Project Name: Gleneagle Golf Course Residential Infill

Project Number: VR 1818

Description: It is proposed to develop Tract G of Gleneagle Golf Course Residential Infill Development as Filing #2 with 12 residential lots on 7.621 acres. The lots are to be located on what was once the Gleneagle Golf Course. This parcel is located in Section 06, Township 12 South, Range 66 West.

GLENEAGLE GOLF COURSE RESIDENTIAL INFILL DEVELOPMENT FILING NO. 2

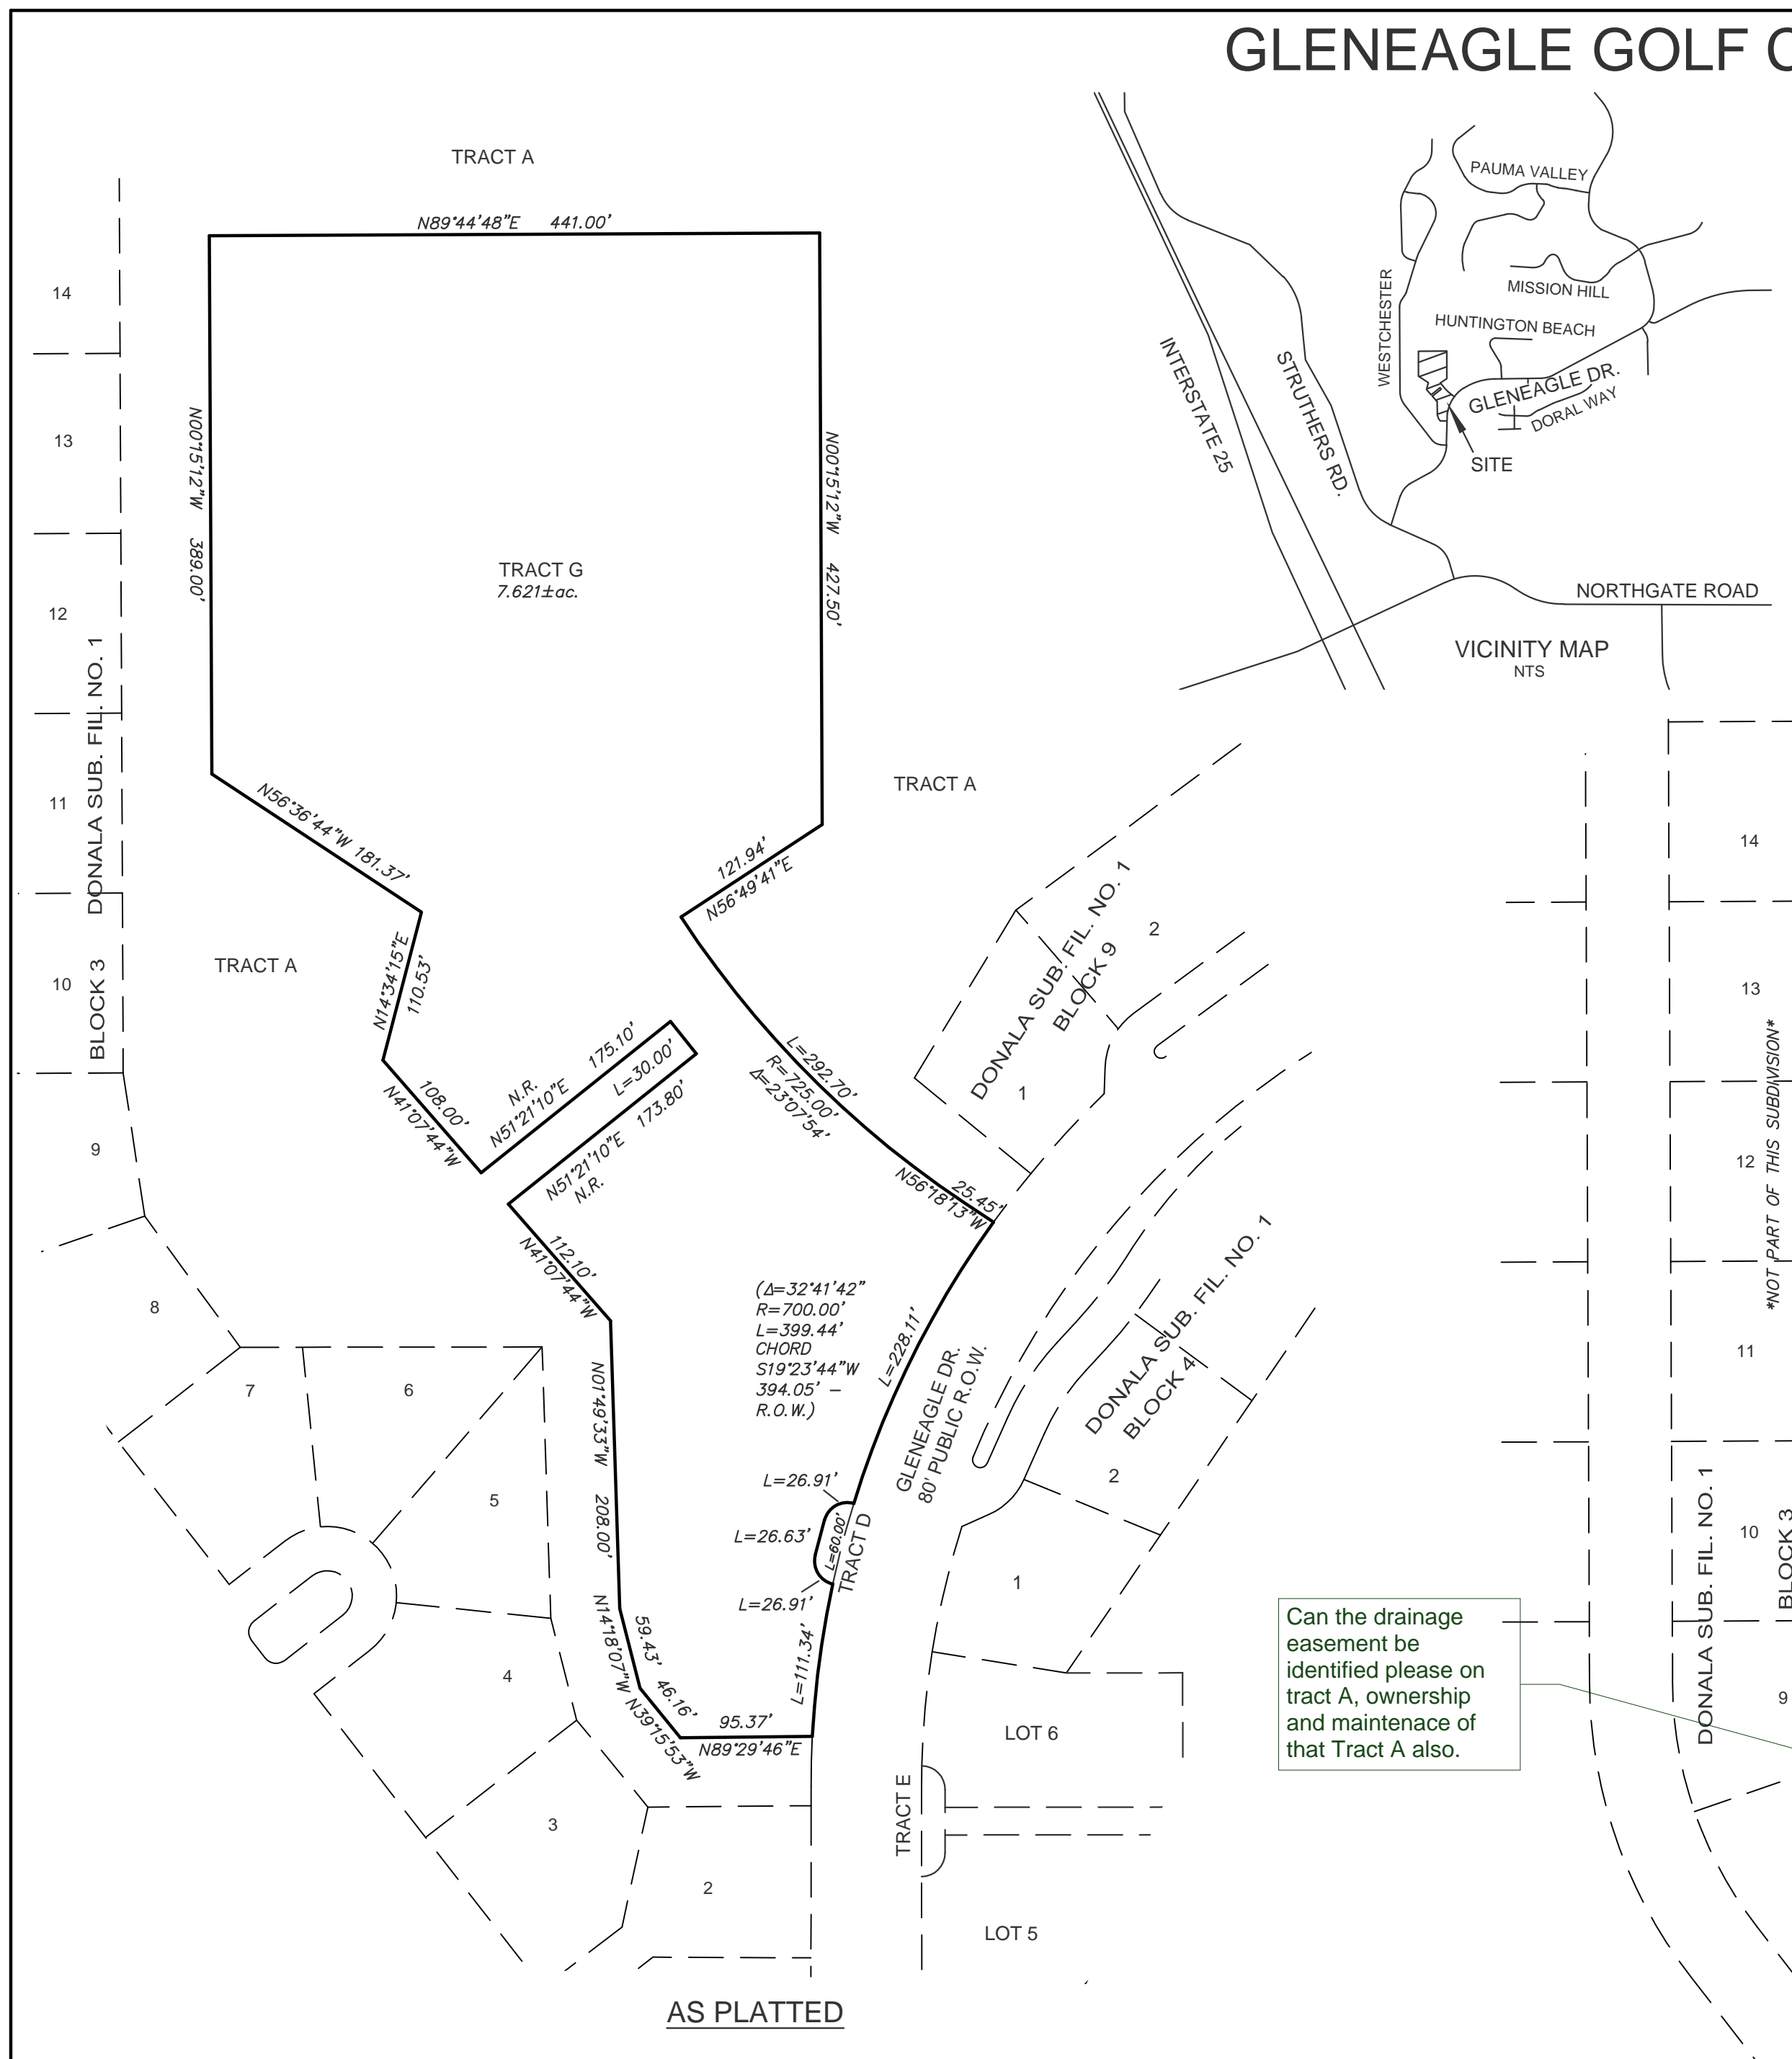
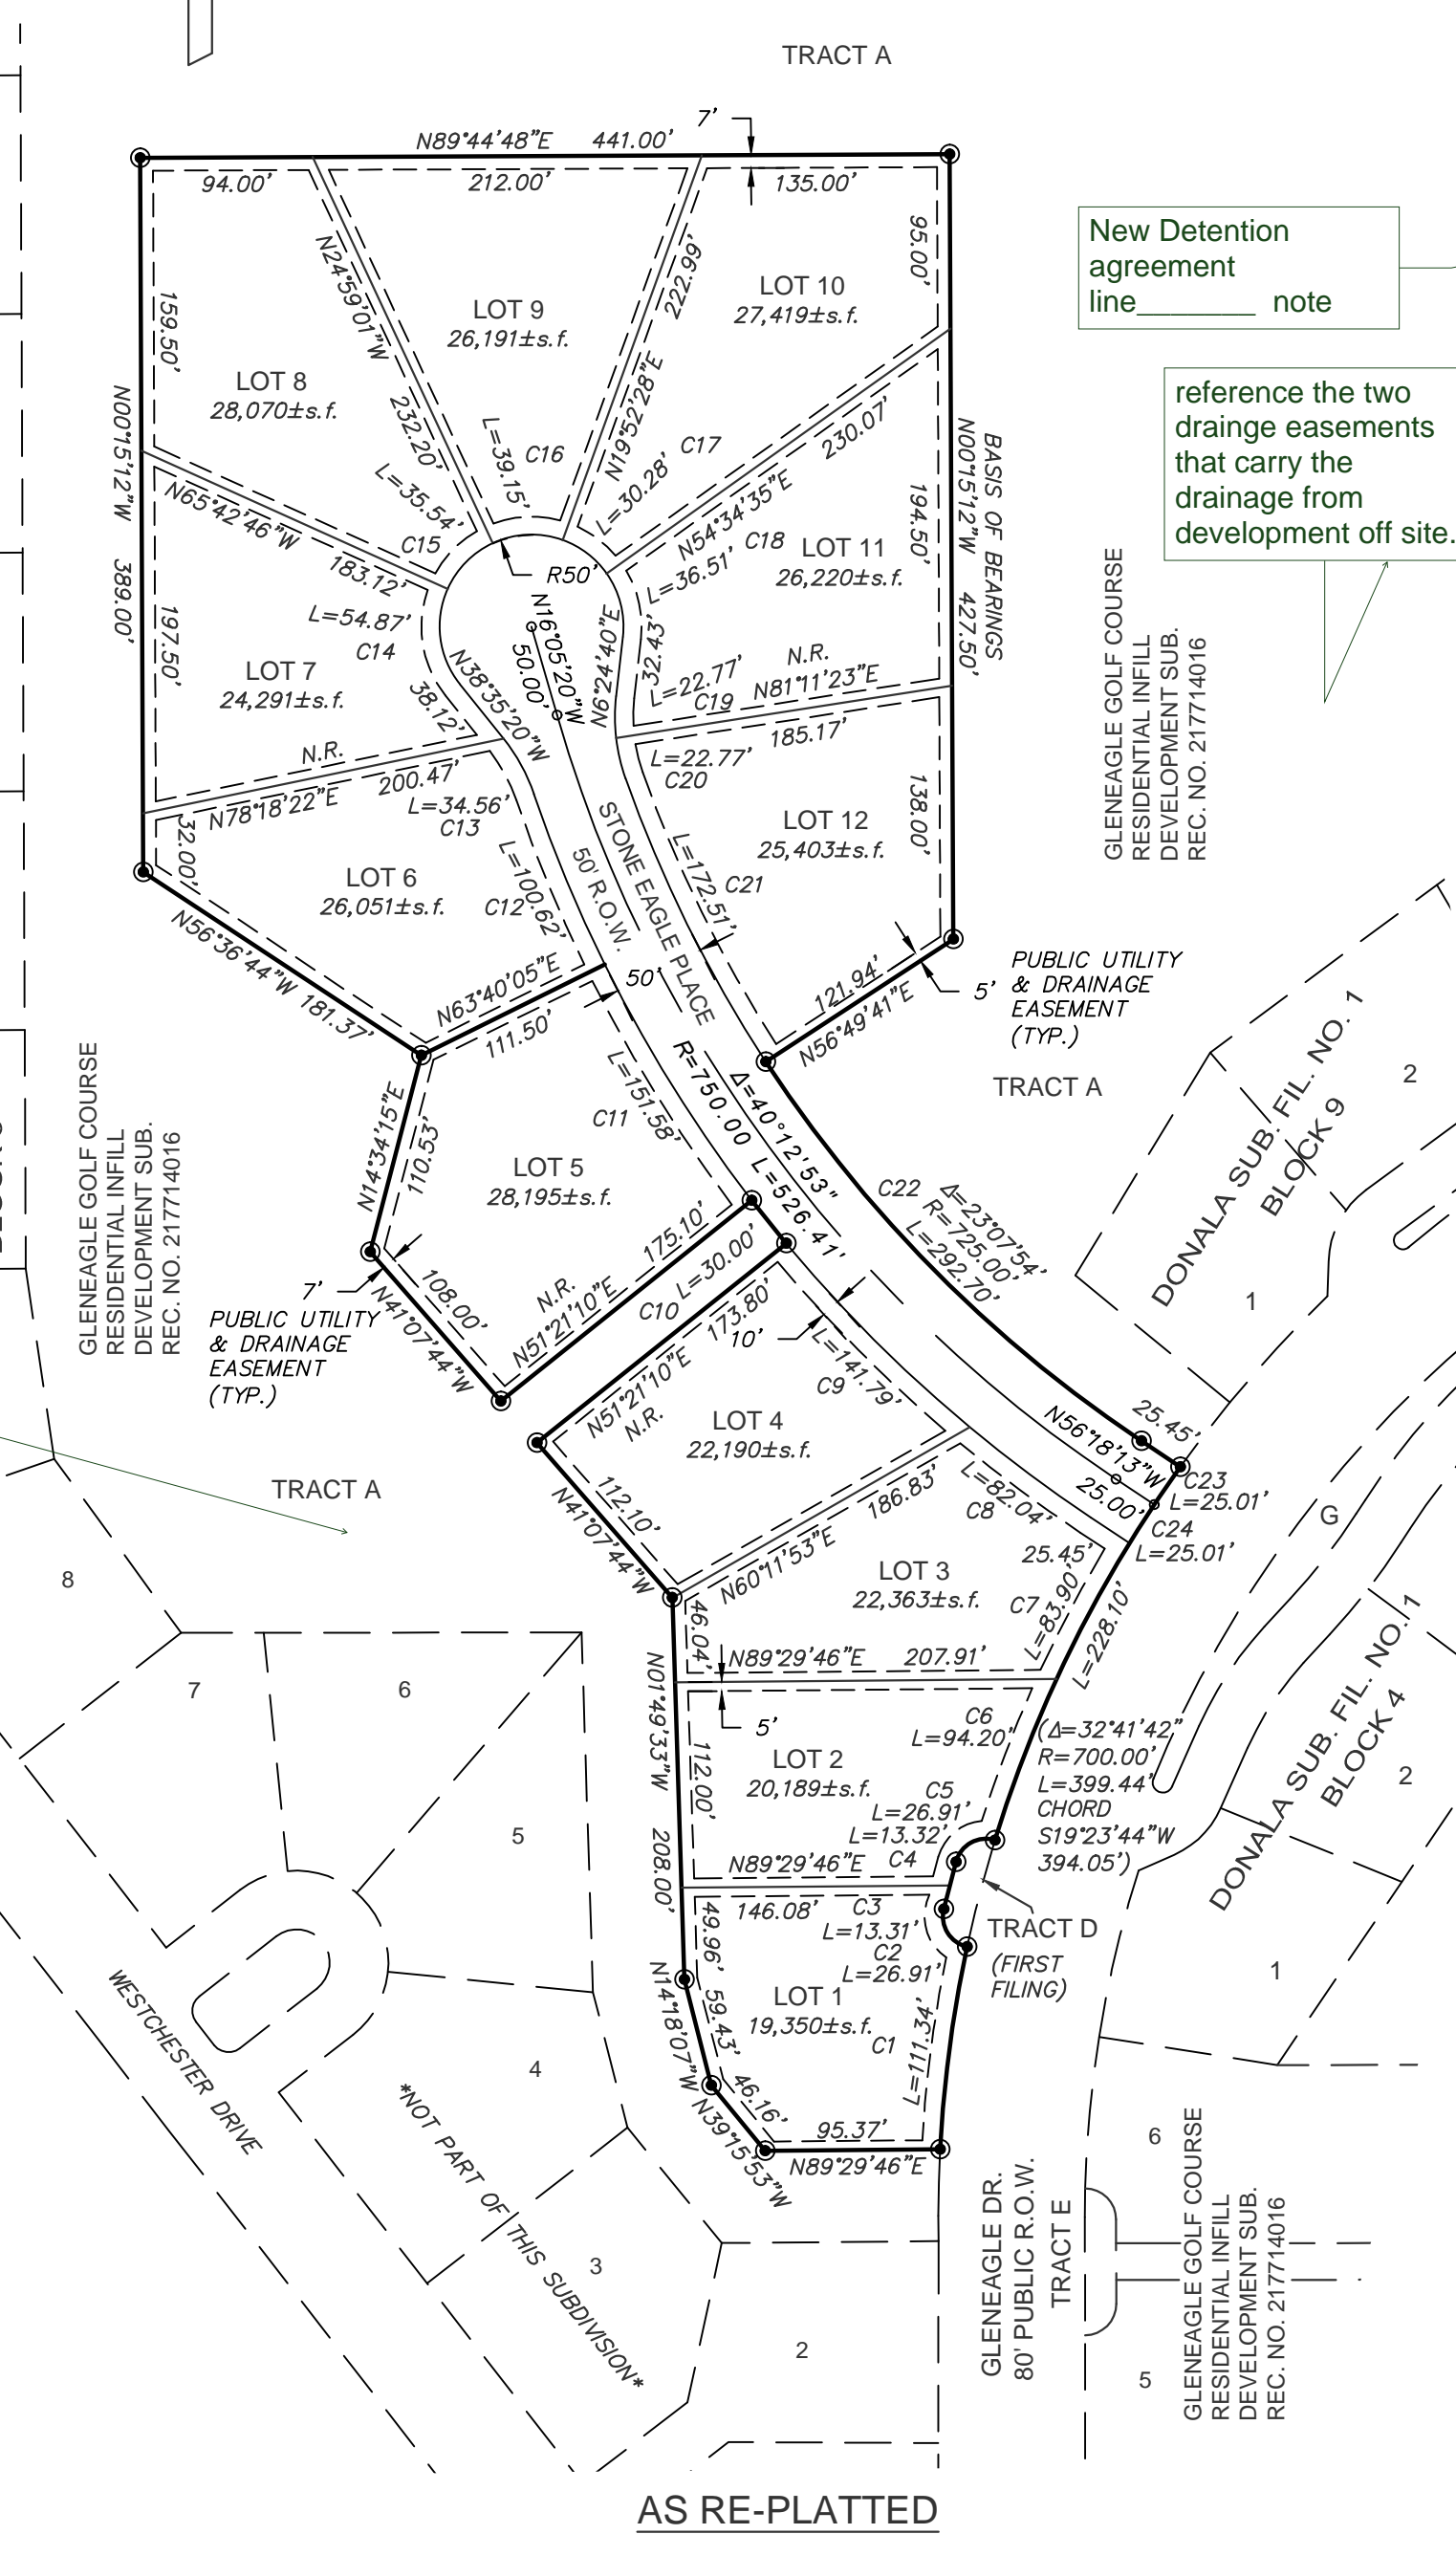
MVEA requests a ten (10) foot front lot utility easement, five (5) foot each side lot line utility easement, and seven (7) foot rear lot line easement. MVEA also requests platting of existing MVEA facilities with easement on the plat. If open space, drainage and landscape tracts are designed in this filing MVEA requests these areas be listed to include utilities. Additional easements may be required once a review of civil drawings with grading and erosion plan is provided to MVEA in order to serve this filing.
